# Tween Bridge Solar Farm

## 9.12 Statement of Common Ground Canal and River Trust

**Document Reference: 9.12**

# Statement of Common Ground

Figure 6.4: Landscape and Visual Mitigation Strategy

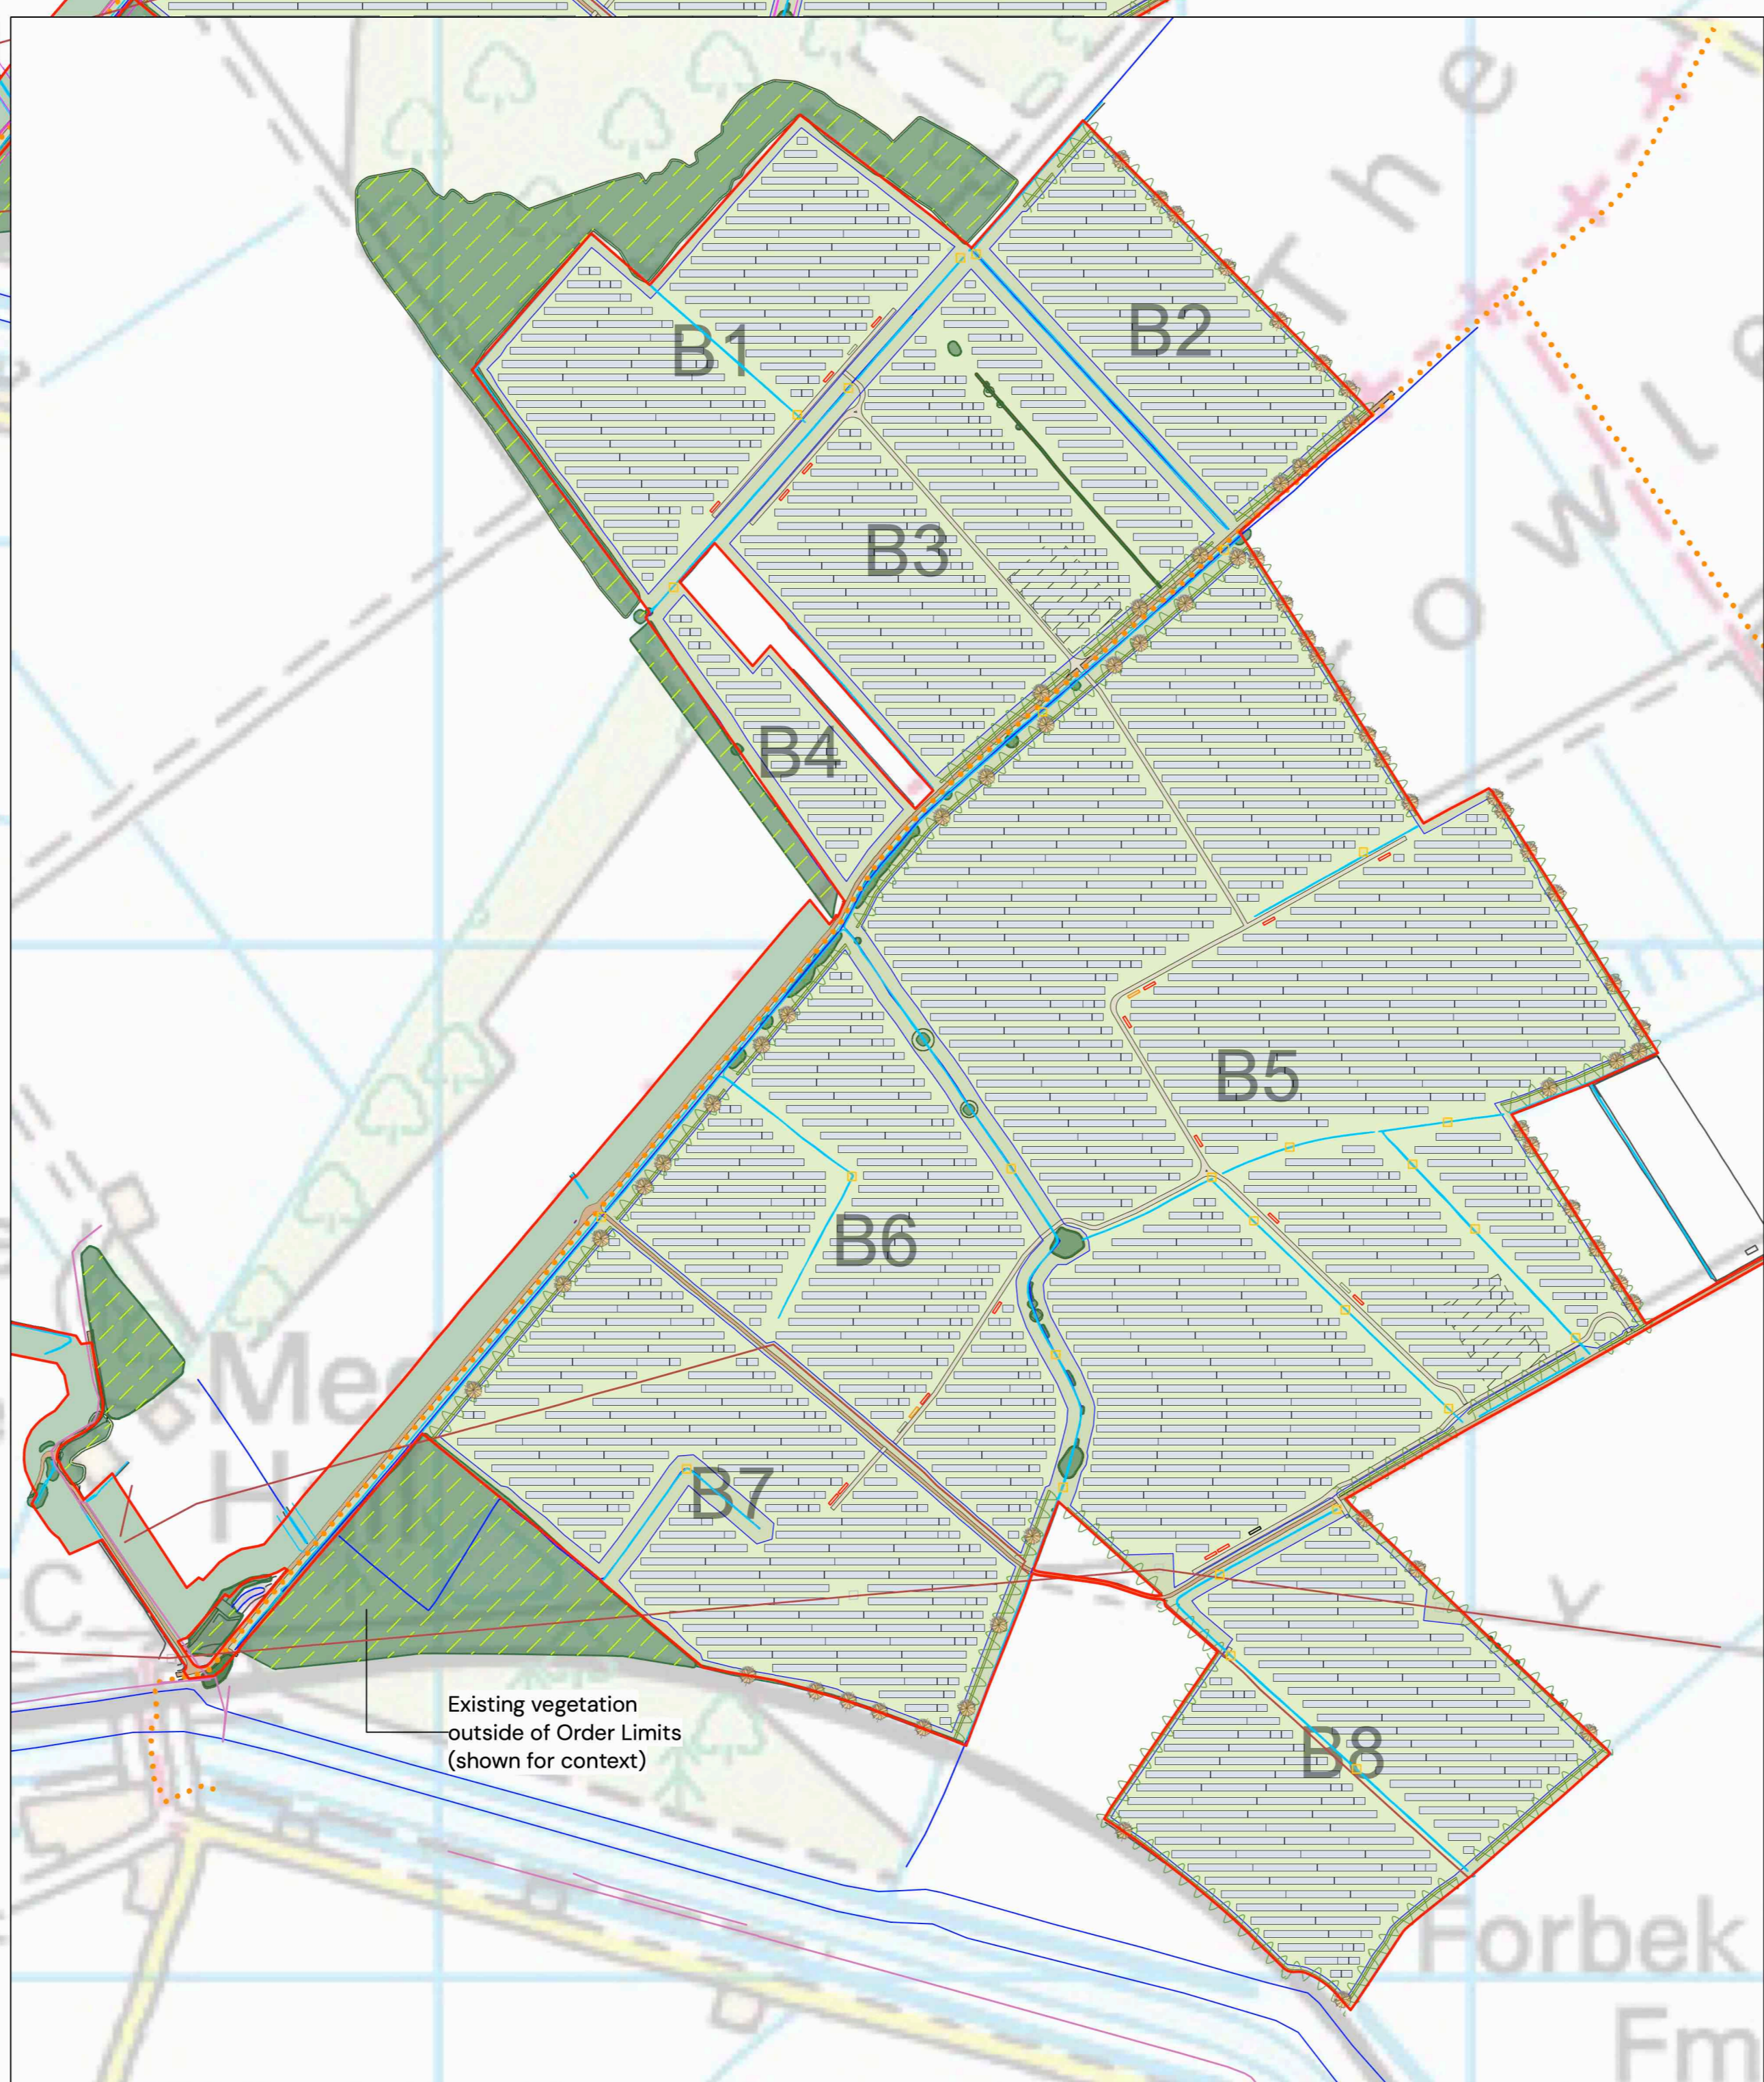
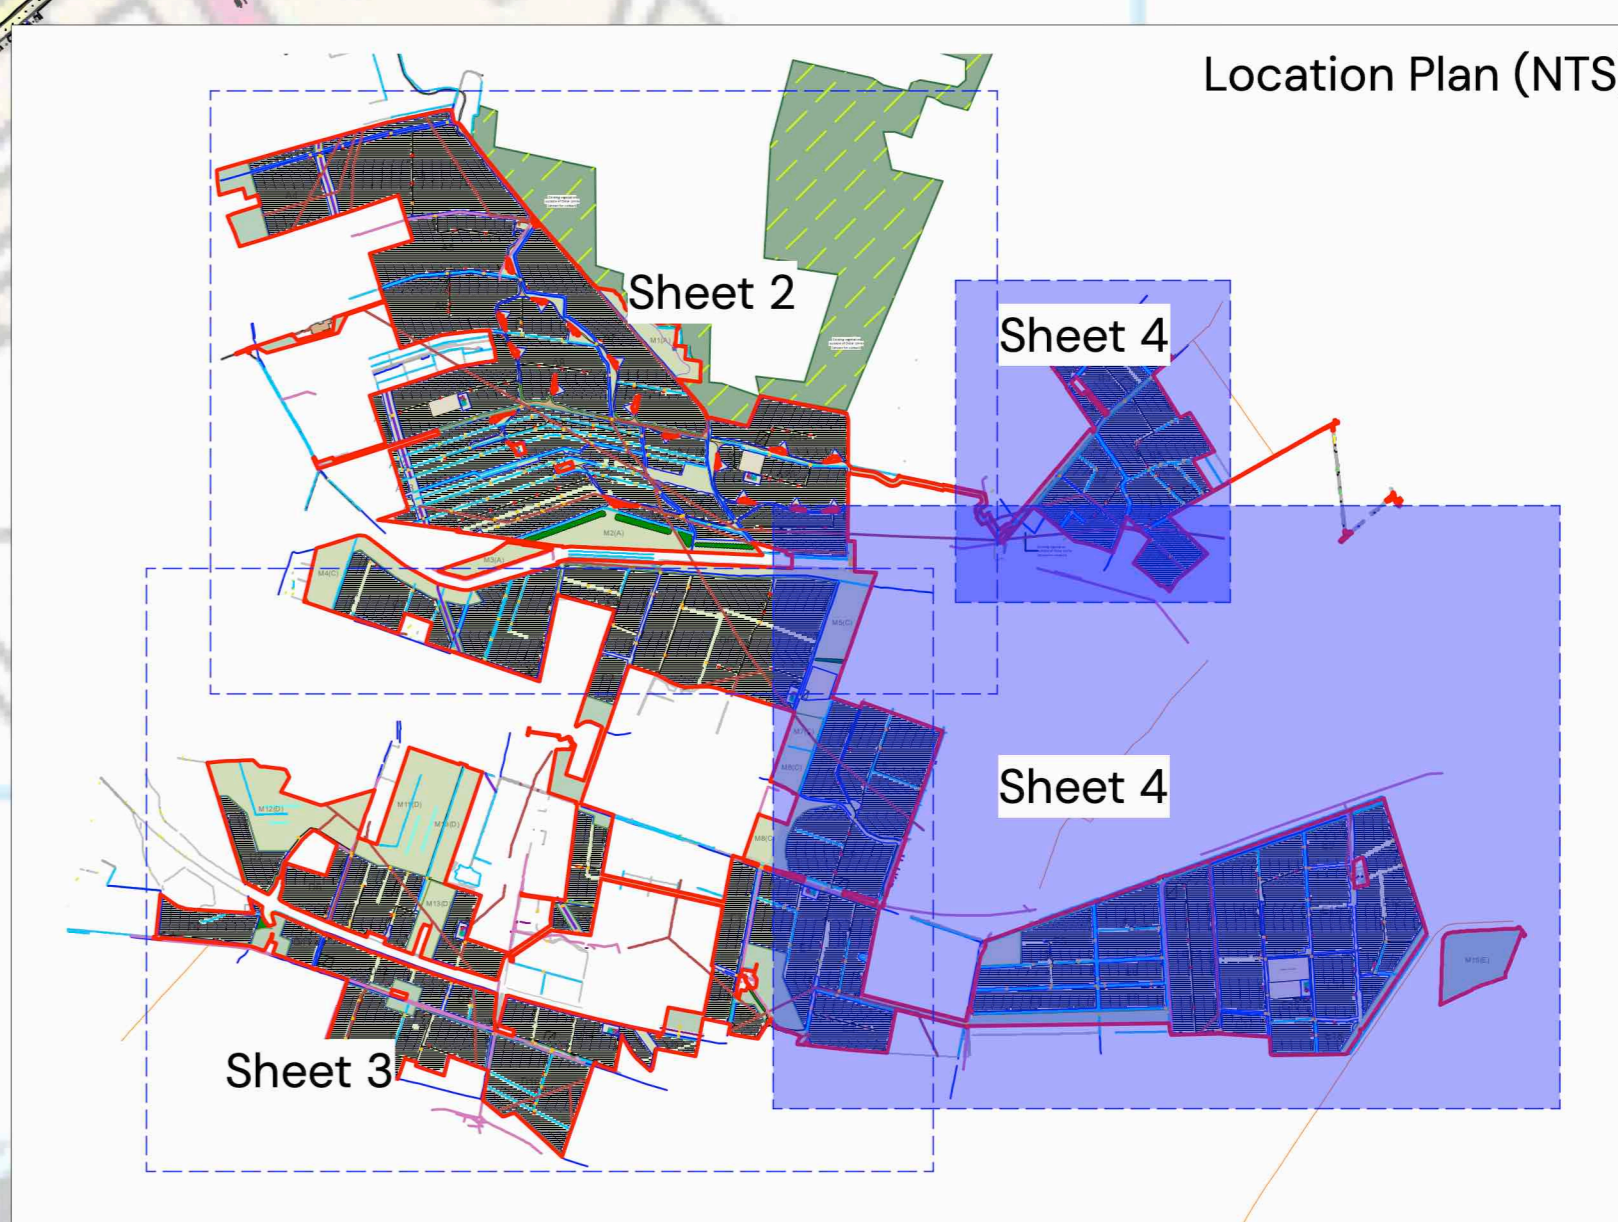
Ref	Topic	CRT Position	Applicant Position	Status
		proposed mitigation measure, comprising of new hedgerow planting, to be appropriate.		
8.	Landscape and visual character – securing of mitigation for the Canal	The CRT requests that the measures highlighted in <b>Figure 6.4 of the ES (Landscape and Visual Mitigation Strategy) [APP-148]</b> are secured and implemented. Additionally, were the Landscape and Visual Mitigation Strategy to be capable of variation post-consent, the CRT would seek to be consulted on any variations affecting the impacts on the Canal.	Requirements 6 and 8 of the <b>draft DCO [Document Reference 3.1 Revision 6]</b> secure the <b>Landscape and Visual Mitigation Strategy [Document Reference 6.4.6.4 Revision 4]</b> . Specifically, requirement 6 controls the detailed design of the Scheme and requires that various design details be submitted for the approval of the relevant planning authority prior to each phase of development commencing. Such details must accord with the Landscape and Visual Mitigation Strategy, amongst other control documents. Requirement 8 sets out the requirement for a written landscape and ecology management plan to be submitted for the approval of the relevant planning authority prior to the commencement of each phase of development. Under requirement 8, the landscape and ecological management plan must be in substantial accordance with the Landscape and Visual Mitigation Strategy, amongst other control documents.	Under discussion

Ref	Topic	CRT Position	Applicant Position	Status
			<p>The Landscape and Visual Mitigation Strategy is Figure 6.4 of the Environmental Statement, and therefore must be certified under article 43 of the <b>draft DCO [Document Reference 3.1 Revision 6]</b> and would be capable of variation post-consent. However, as confirmed by requirement 5, this would only be with the approval of the relevant planning authority and provided it had been demonstrated to their satisfaction that the subject matter of the approval would not give rise to any materially new or materially different environmental effects from those assessed in the ES. In the event a submission was made under requirement 5 in relation to the Landscape and Visual Mitigation Strategy, the Applicant anticipates that the relevant planning authority would consult the CRT in confirming its satisfaction that any changes proposed would not give rise to materially new or different effects.</p> <p>The Applicant requests confirmation from the CRT as to whether this matter is now agreed.</p>
